Rezoning Transportation Analysis

Petition Number: 2020-123

Date	Description
09-11-2020	First Review (KP)
10-19-2020	Second Review (KP)

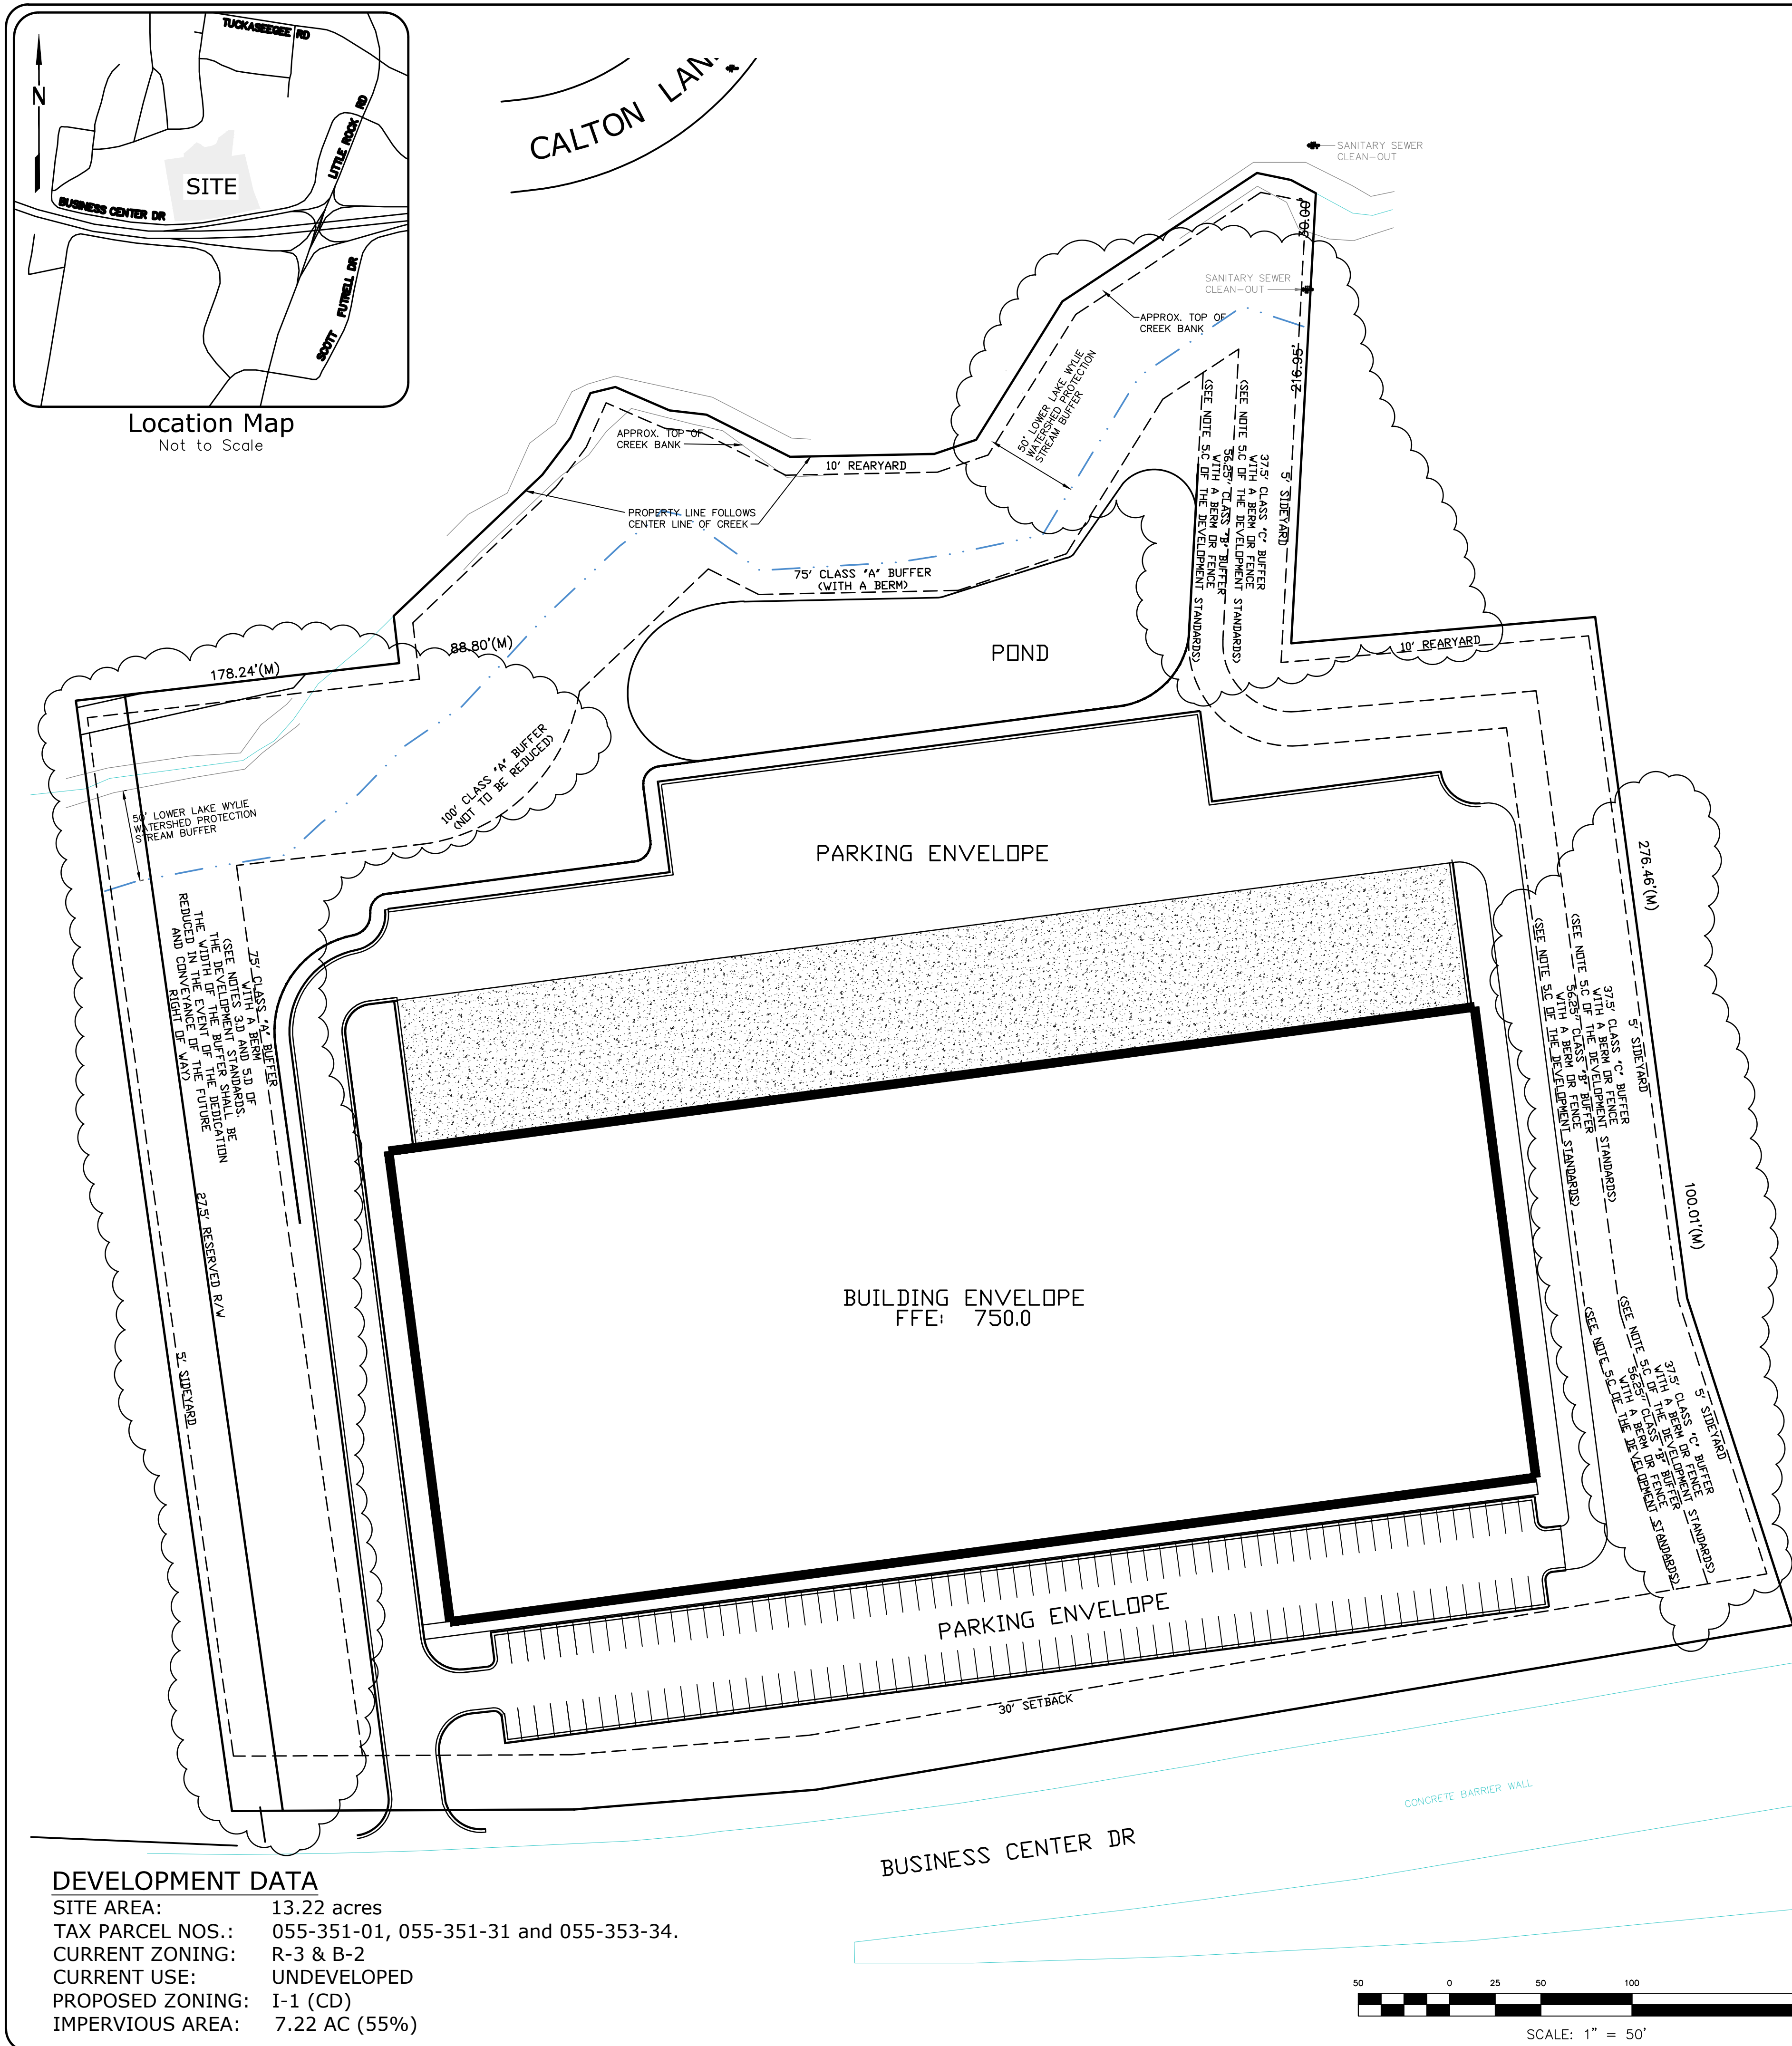
- Revise the site plan and conditional note(s) to commit to dedicate right-of-way 2-ft back-of-sidewalk on Business Center Drive, labeled and dimensioned from the road centerline.

- New comment 10-12-20 Site Plan:** Please show right-of-way on the site plan.
- Revise the site plan and conditional note(s) to commit to construct an 8-foot planting strip and a 6-foot sidewalk along the site's Business Center Drive frontage, per Charlotte WALKS, labeled and dimensioned from the road centerline.

- New comment 10-12-20 Site Plan:** Please show sidewalk and planting strip on the site plan.
- ~~Revise the site plan and conditional note(s) to commit to constructing a public street to the west of the property, constructed relative to U-06, local industrial section, in the Charlotte Land Development Standards Manual.~~
